Hornsea Project Three
Offshore Wind Farm

Response to the Secretary of State's Consultation Appendix 11: Draft Development Consent Order Schedule of Changes

Date: February 2020

Schedule of Changes to the Draft Development Consent Order

Figure 3.9: Indicative Layout A with 300 turbines and 19 platforms.

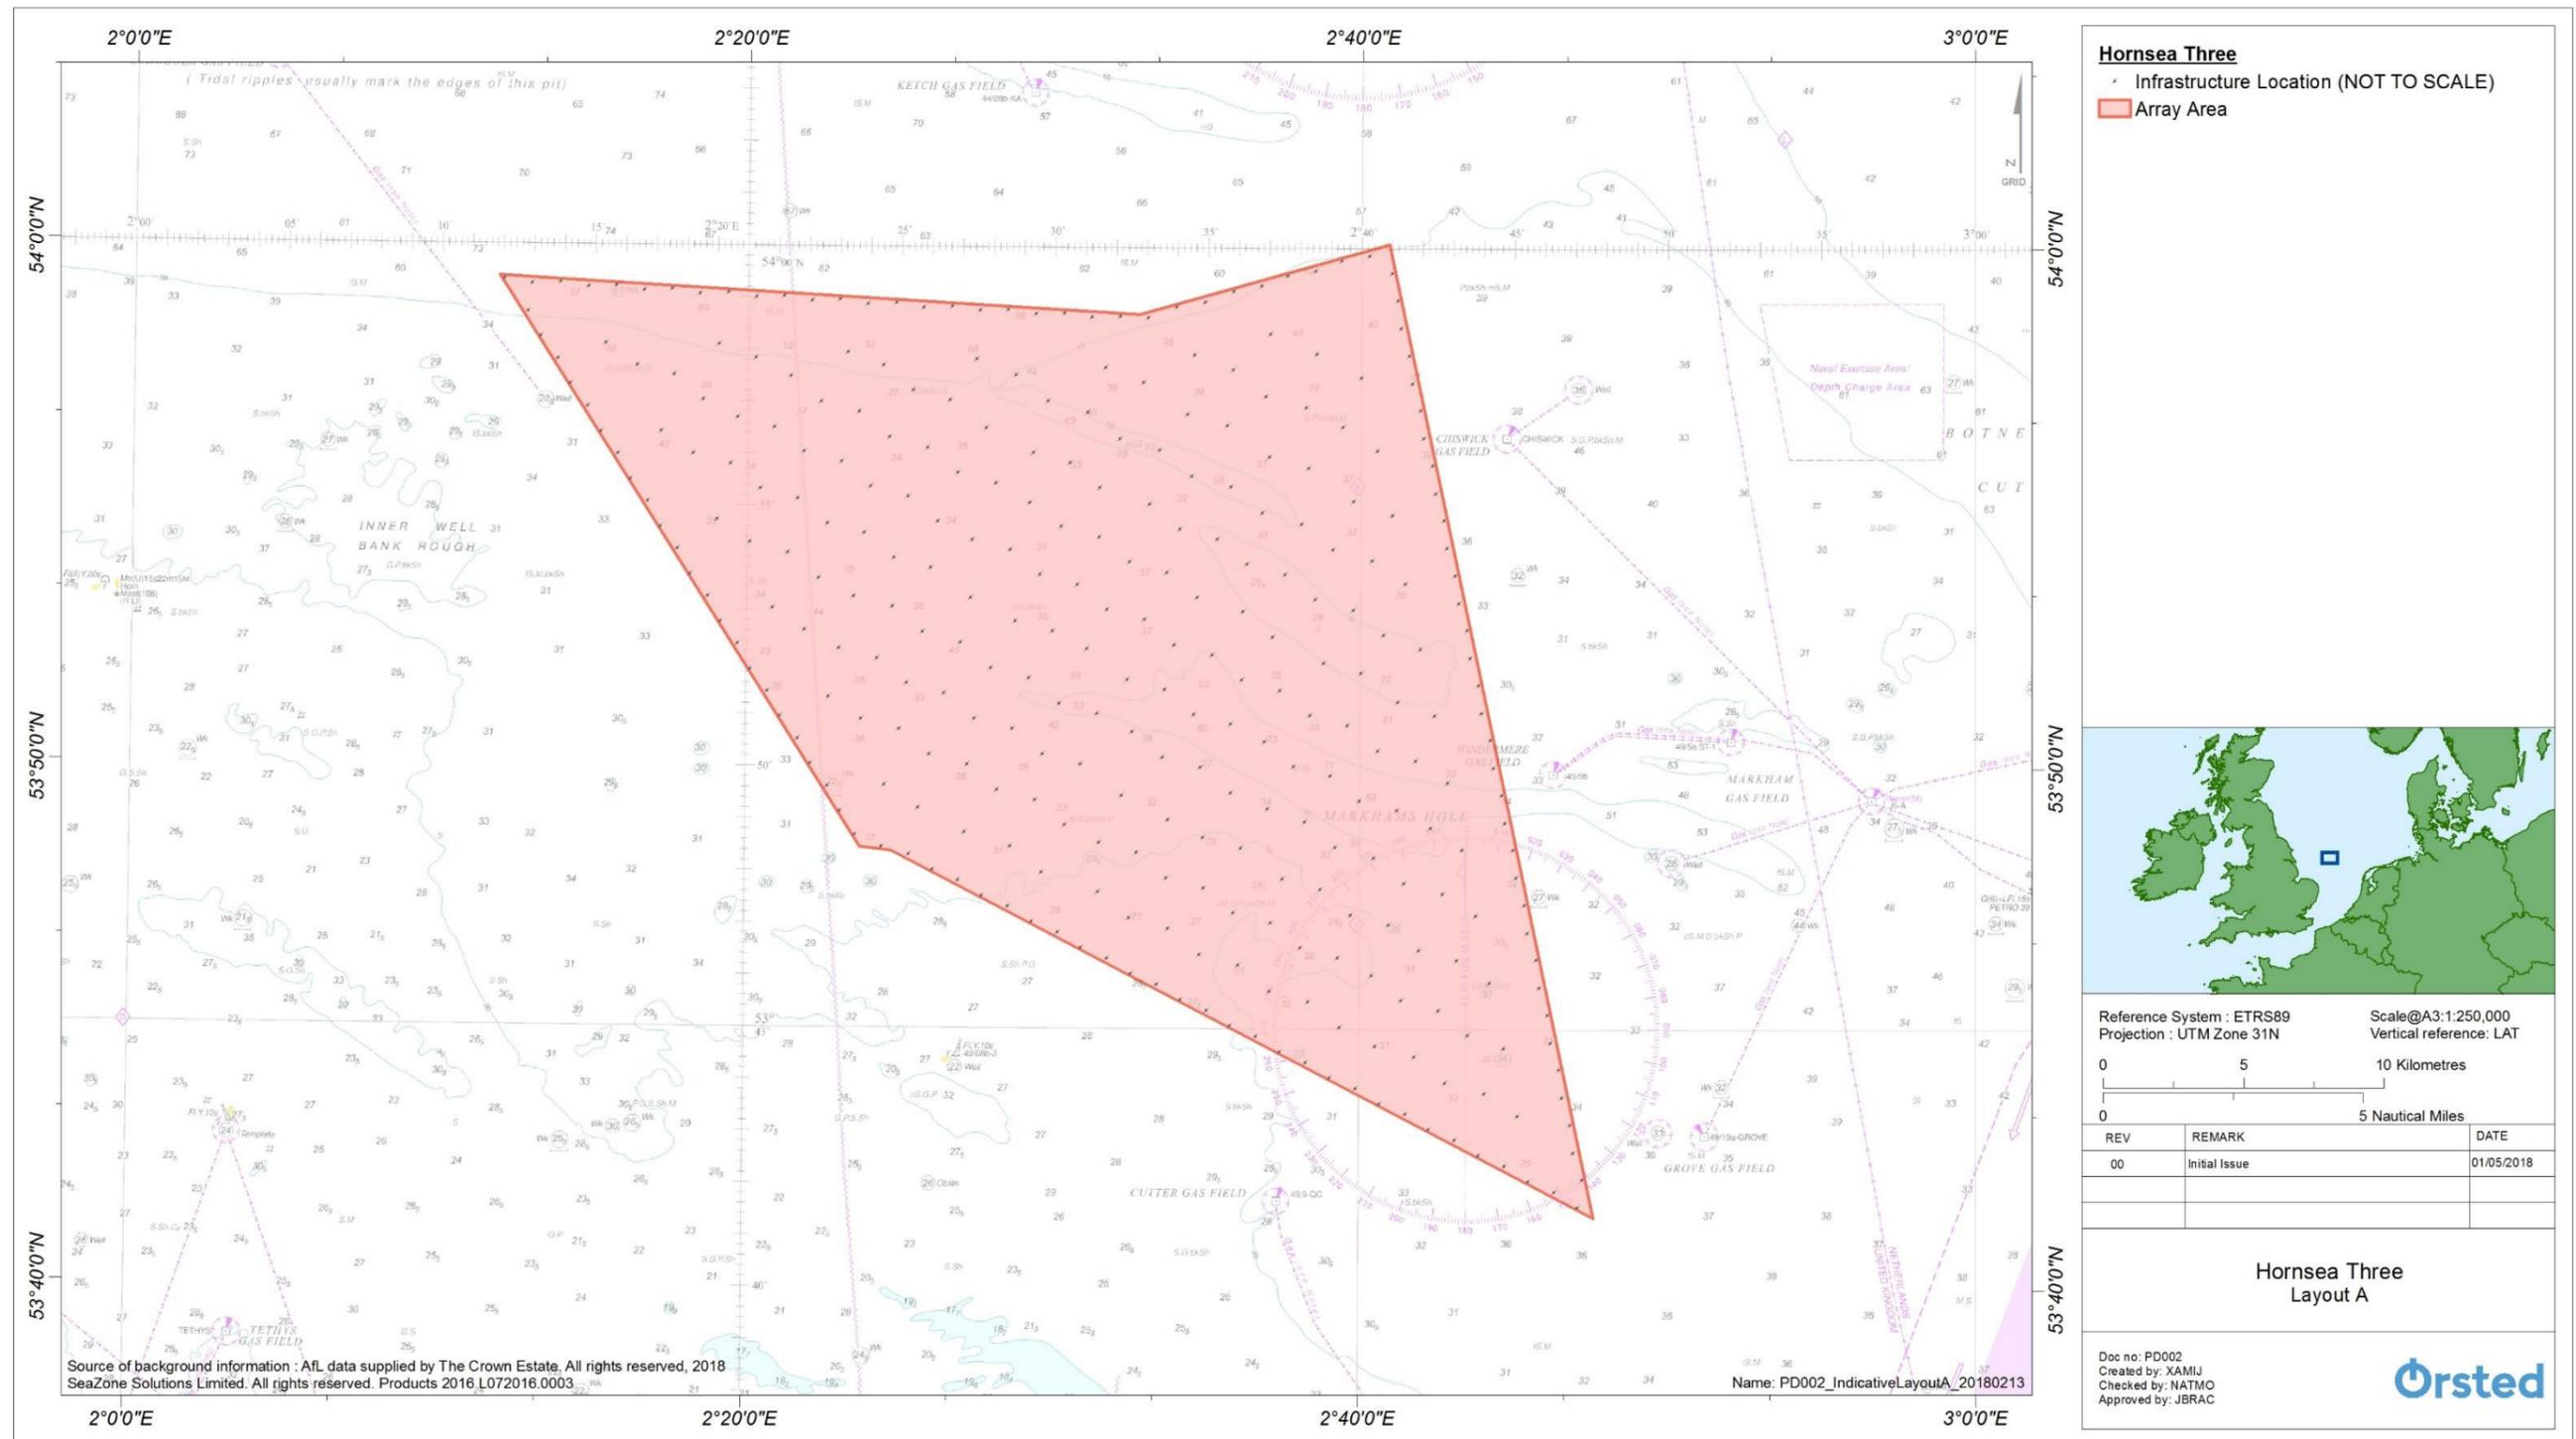
Article 36. - Certification of plans and documents, etc.	Applicant	Amended to add in new plans (see above and below) and reordered to alphabetical order, for clarity and ease of reference.	See dDCO.
Article 44. - Compensation and MEEB measures	Applicant	Added to give effect to new Schedule 14 (Compensation and MEEB measures).	<i>Compensation and MEEB measures</i> <i>44. Schedule 14 (Compensation and MEEB Measures) has effect.</i>
SCHEDULE 1 — Authorised project			
PART 1 - Authorised Development			
Work No.1	Applicant	Amendments to reflect post-examination design and mitigation review	an offshore wind turbine generating station with a gross electrical output of over 100 megawatts comprising up to 300 231 wind turbine generators each fixed to the seabed by either monopile foundation, mono suction bucket foundation, jacket foundation or gravity base foundation;
Requirement 2 - Detailed offshore design parameters	Applicant	Amendments to reflect post-examination design and mitigation review	2.—(1) The total number of wind turbine generators comprised in the authorised project must not exceed 300 231 and a total rotor swept area of 9 8.8 square kilometres.

Figure 3.1: Marine Conservation Zones (MCZs) and recommended Marine Conservation Zones (MCZs) overlapping Hornsea Three or within one tidal excursion of Hornsea Three with relevant protected/proposed features.

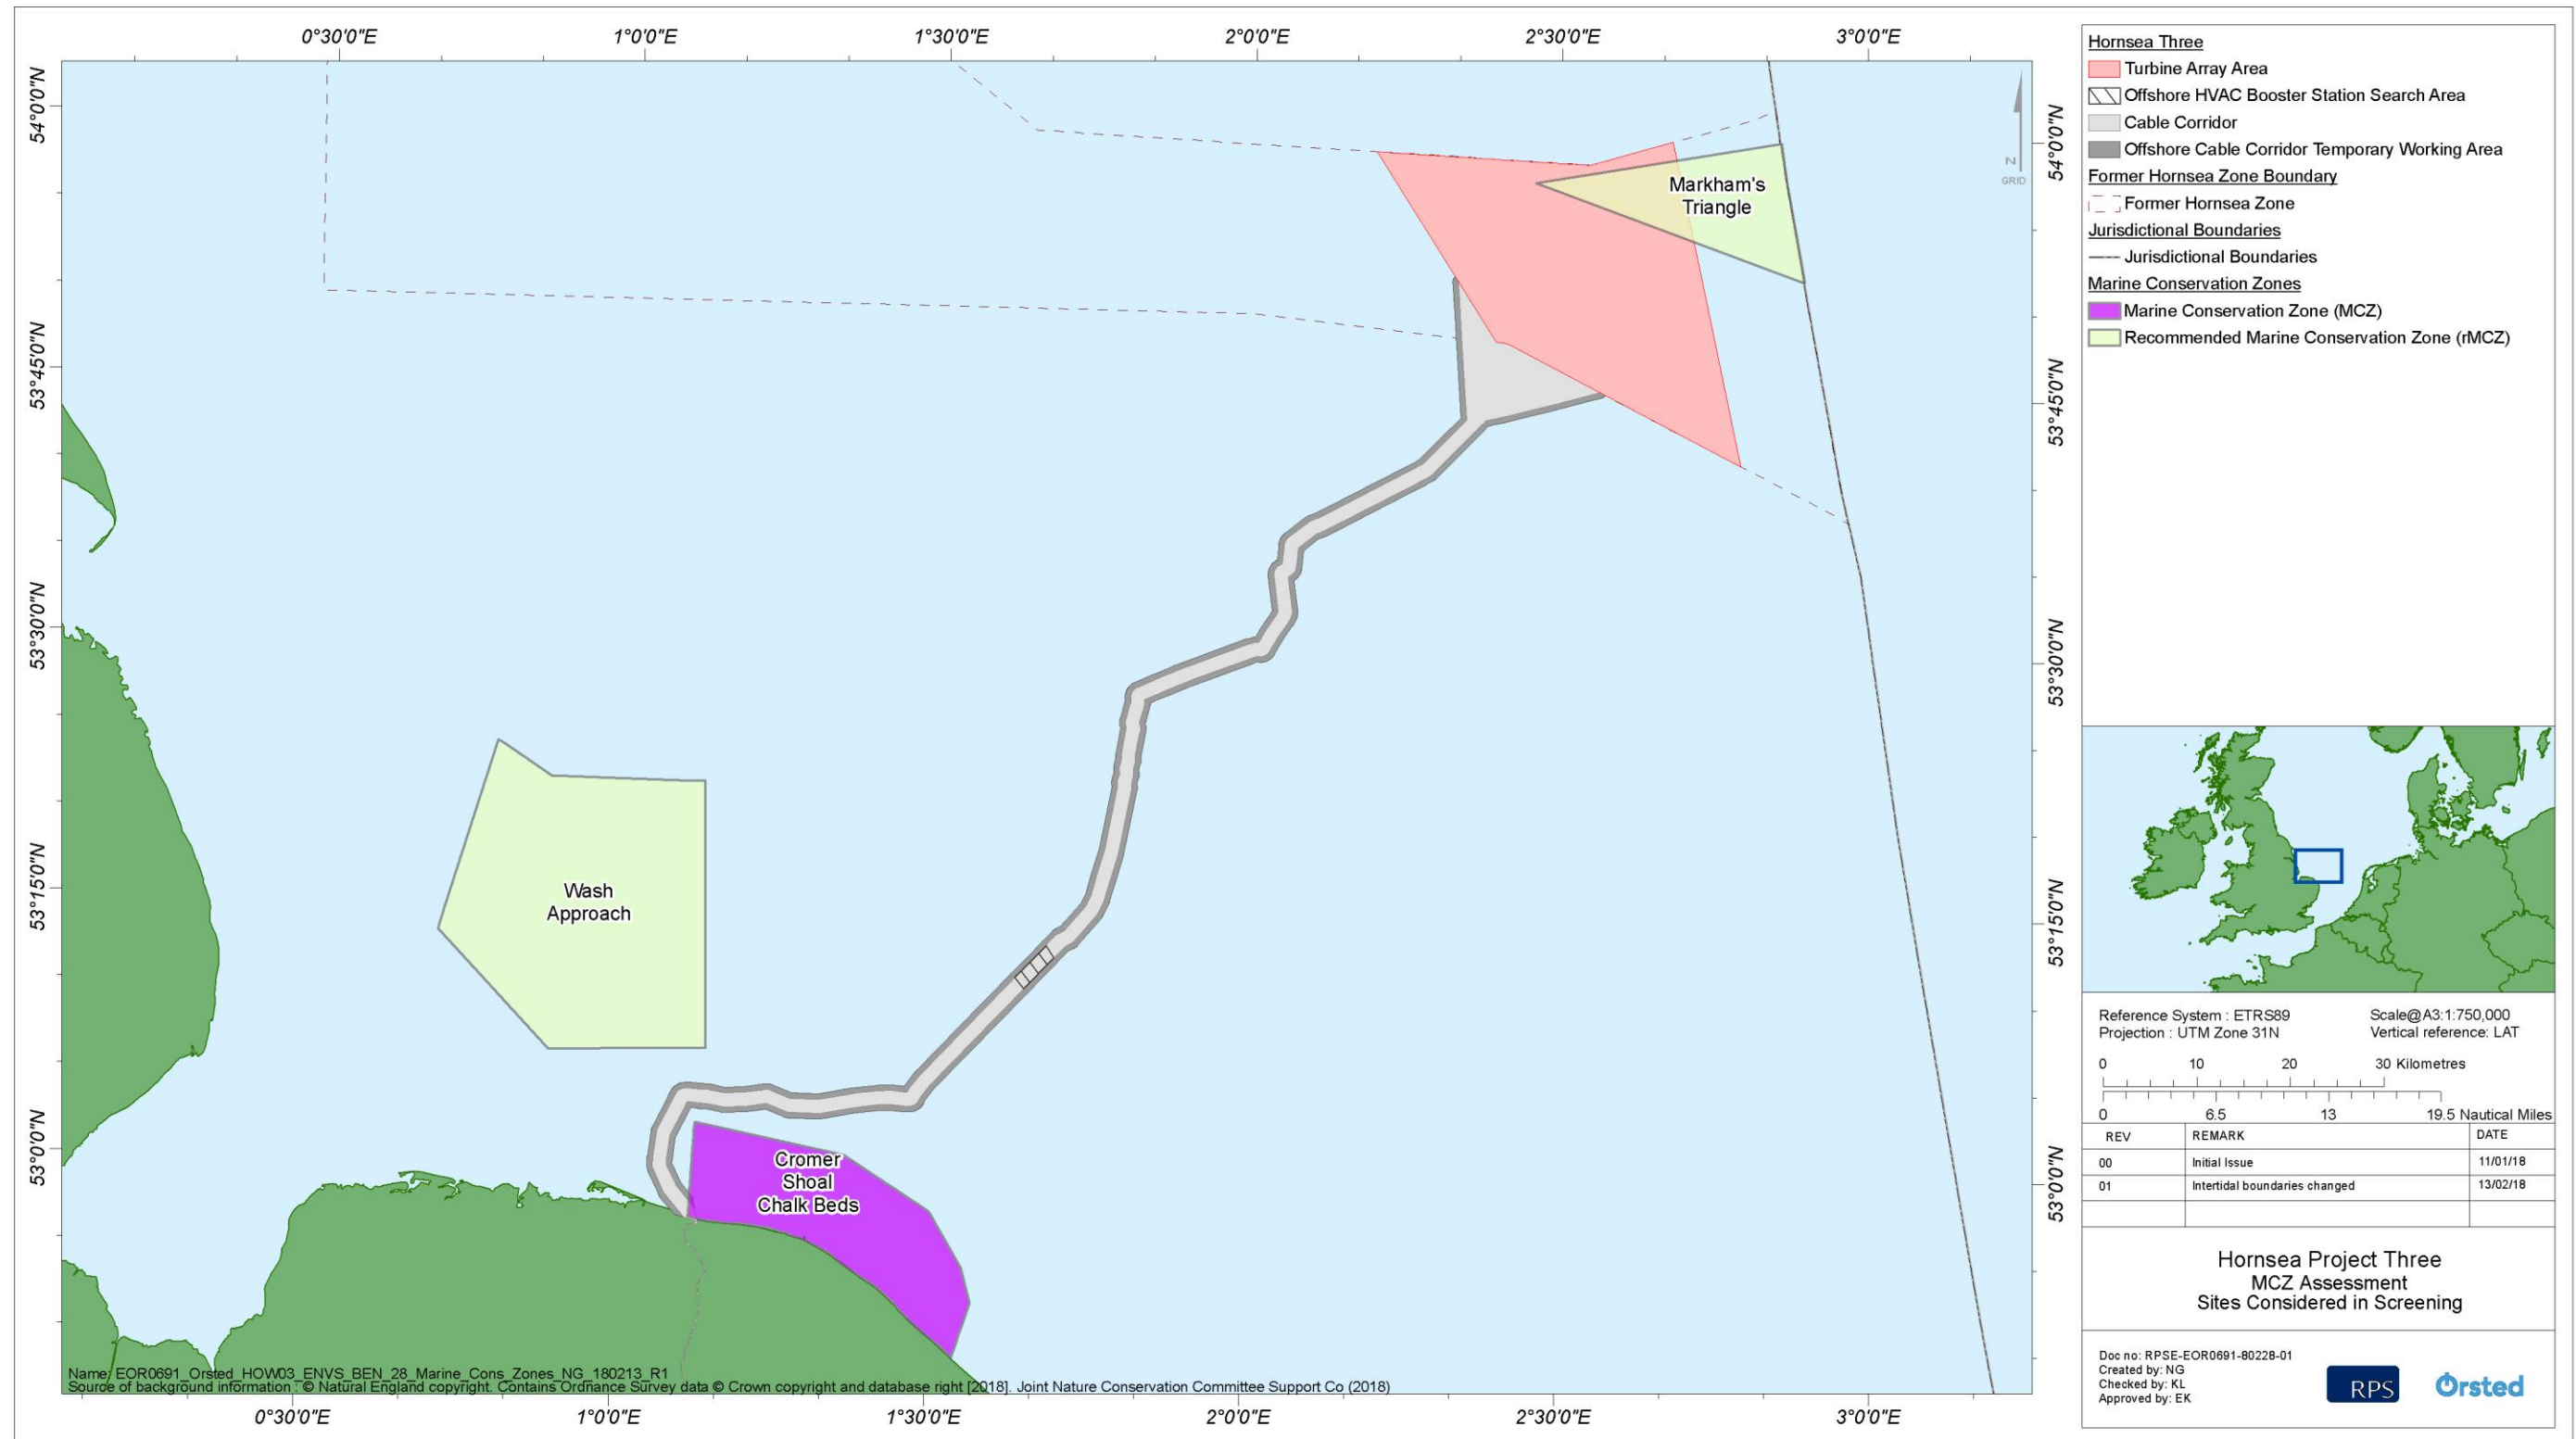
<p>Article 1 Interpretation - Applicant</p>	<p>Amended to refer to Markham’s Triangle following designation as an MCZ, and to introduce exclusion zone plan to assist defining this area.</p>	<p>“Markham’s Triangle rMCZ” means the recommended MCZ shown on Figure 3.1 of Volume 5, Annex 2.3 of the environmental statement;</p> <p>“Markham’s Triangle MCZ” means the MCZ designated by the Secretary of State under the Markham’s Triangle Marine Conservation Zone Designation Order 2019;</p> <p>“Markham’s Triangle MCZ exclusion zone” means the area comprising Markham’s Triangle MCZ as shown on the Markham’s Triangle exclusion zone plan;</p> <p>“Markham’s Triangle exclusion zone plan” means the document certified as the Markham’s Triangle exclusion zone plan by the Secretary of State for the purposes of this Order under article 36 (certification of plans and documents etc);</p>
